Request for further information - R/2014/13/D

Council staff have reviewed the subject modification for the Art Gallery of NSW and request further information to assist in understanding the impacts of the proposal. In particular:

drawn Architectus project no 140419					drawing no. DA_2052
				Do not scale drawings.					Revision A

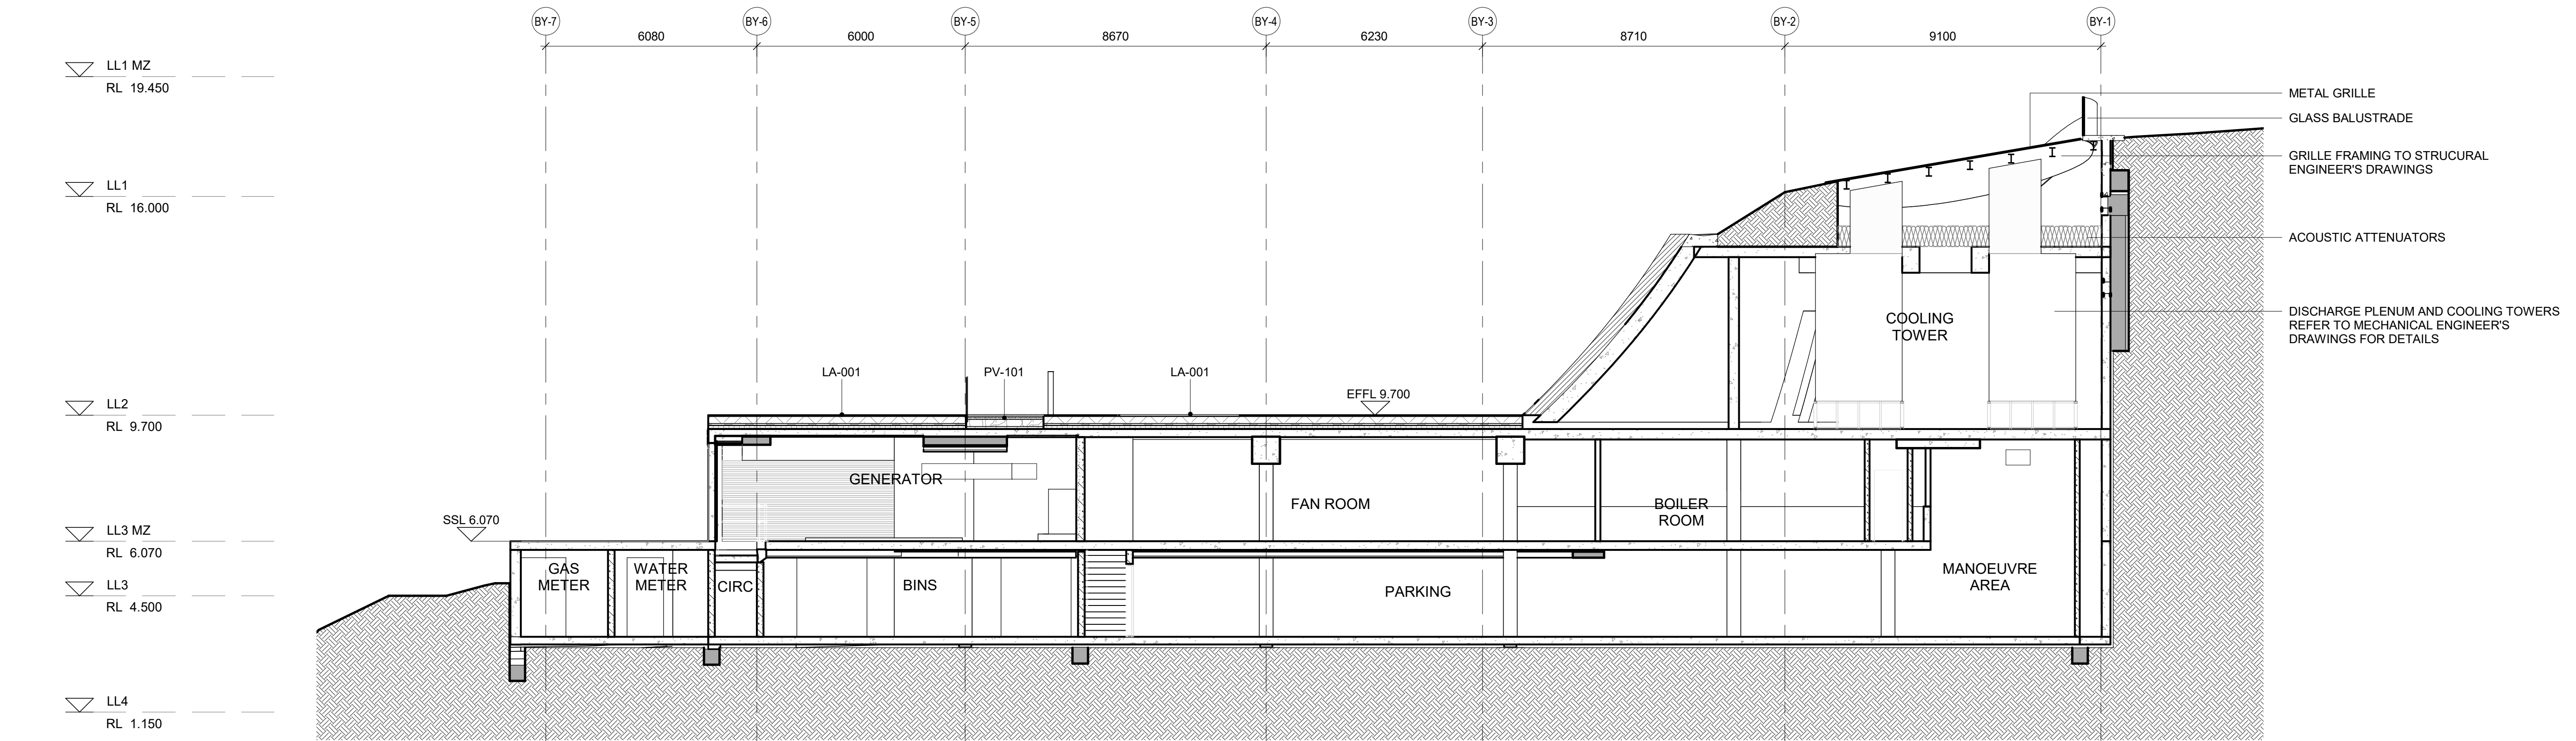
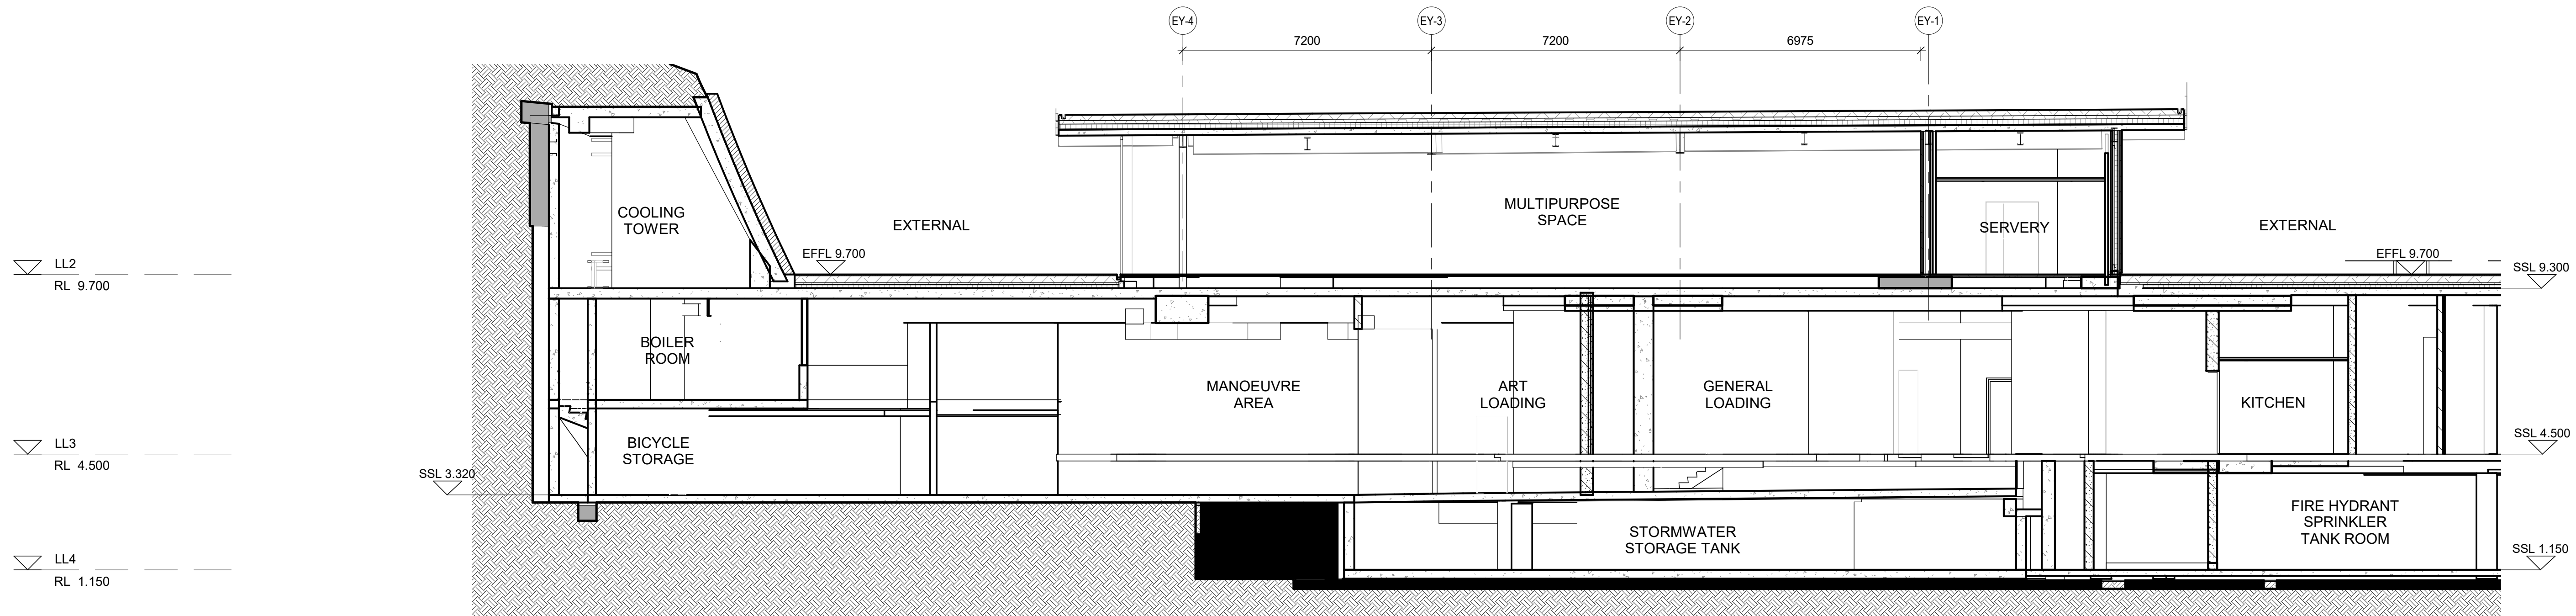
- What are the driving forces in abandoning the seawater heat rejection system?
- What measures will be taken by the landscape architects to mitigate heat on trees and plants in the vicinity of the exhaust?
- What consideration has been given to the impact of the heat exhaust on pedestrian comfort?
- Further information or commitments are required regarding harvesting rainwater to minimise water use for the cooling towers.
- Sections and RLs are required to identify the height of the grill relative to the surrounding area.
